WEST SUSSEX COUNTY COUNCIL CONSULTATION

TO:	Arun District Council FAO: Emma Sheppard
FROM:	WSCC – Highways Authority
DATE:	24 October 2025
LOCATION:	Units 5-7 Watersmead Business Park Norway Lane Worthing Road Littlehampton BN17 6LS
SUBJECT:	LU/93/25/PL Part demolition, conversion, refurbishment and re-elevation of Units 5 and 6 and construction of retail (food and non-food), leisure and food & beverage units (Use Class E), together with associated car parking, access, loading areas, landscaping and associated works. This application is in CIL Zone 2 and is CIL Liable. Response to National Highways-Trips and Distribution 3 July 2025. Additional plans and response to Highways comments.
DATE OF SITE VISIT:	n/a
RECOMMENDATION:	No Objection

WSSC Highways response dated 24th October 2025

title
**PROPOSED HIGHWAY IMPROVEMENTS
AND SITE ACCESS ARRANGEMENT**

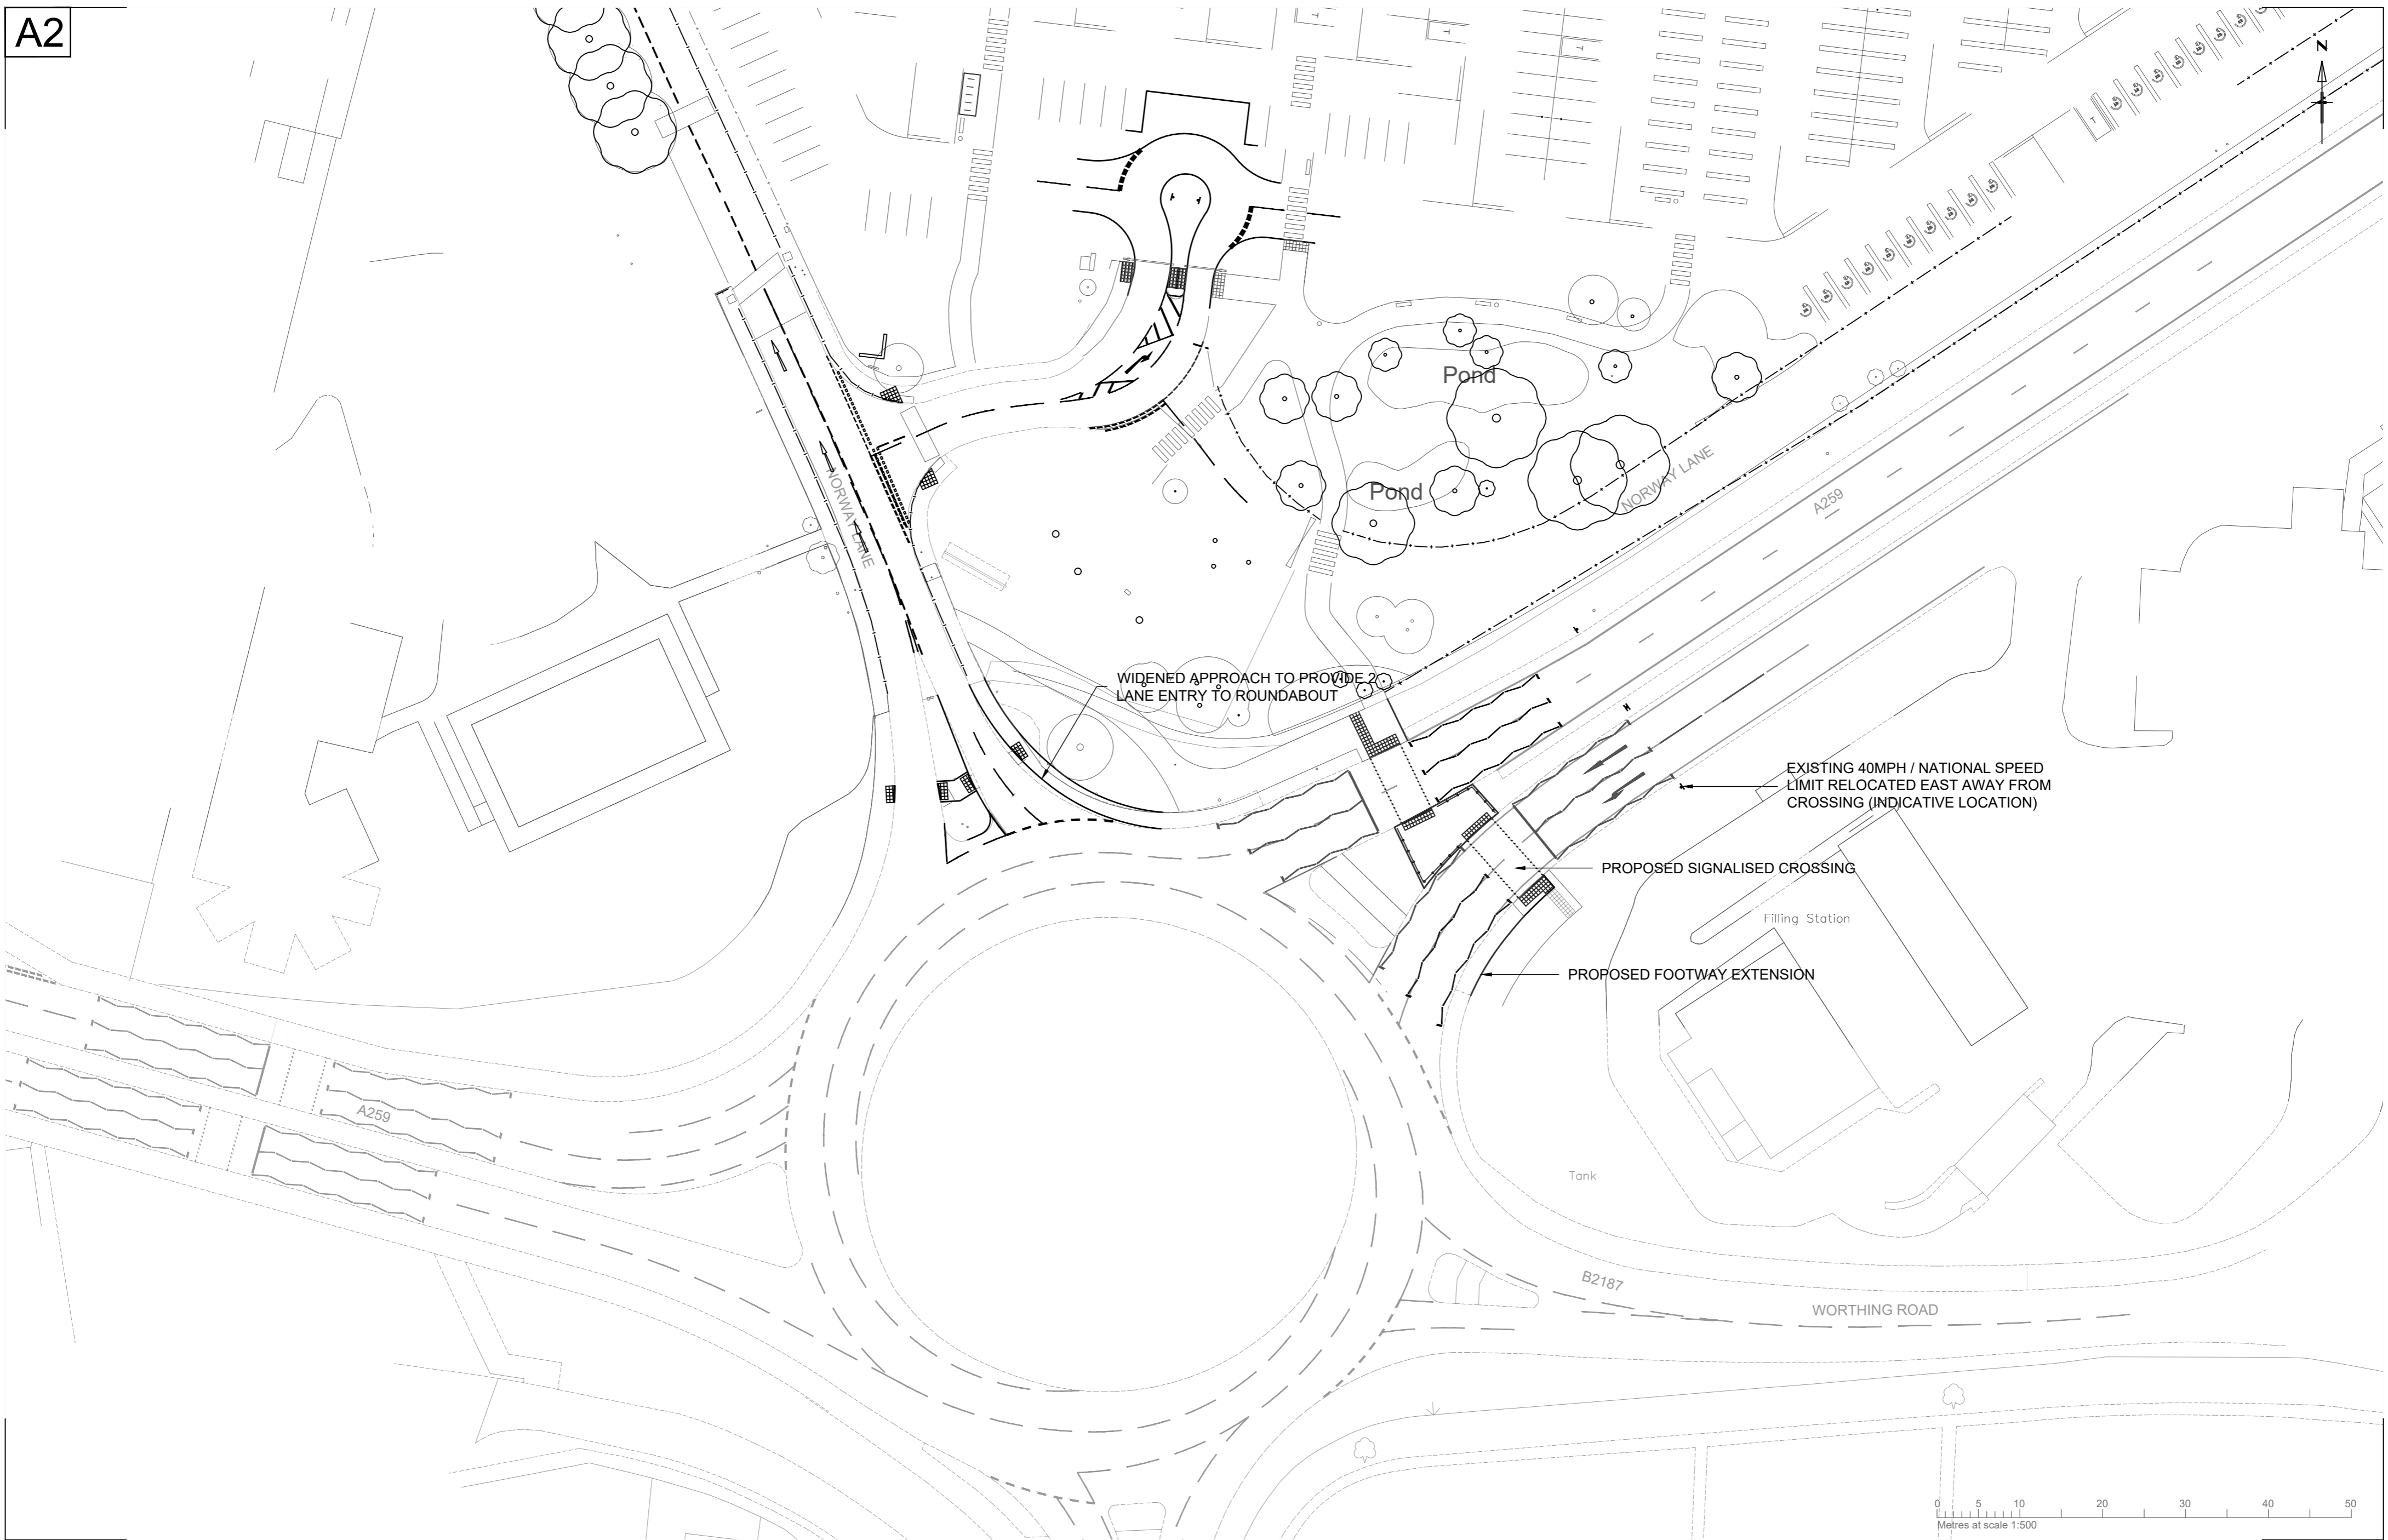
2. *Can the Toucan crossing design be updated incorporating WSCC Traffic Signals and Road Safety Group comments including the proposed extent of the 40mph speed limit.*

The drawing titled 'Proposed Highway Improvements and Site Access Arrangement' (24084-010 Rev C) has been reviewed by the Principal Traffic Engineer at West Sussex County Council (WSCC). The Engineer is satisfied with the changes incorporated into the drawing and has raised no concerns at this stage.

The current version of the drawing does not show the following reinstatement works, which must be included for completeness and implementation clarity:

- Reinstatement of the existing footway on the central reservation back to grass.
- Removal of all dropped kerbs on either side of the A259, and reinstatement to full-height kerbs.

These elements are essential to ensure the final design reflects all necessary changes and can be implemented as approved.
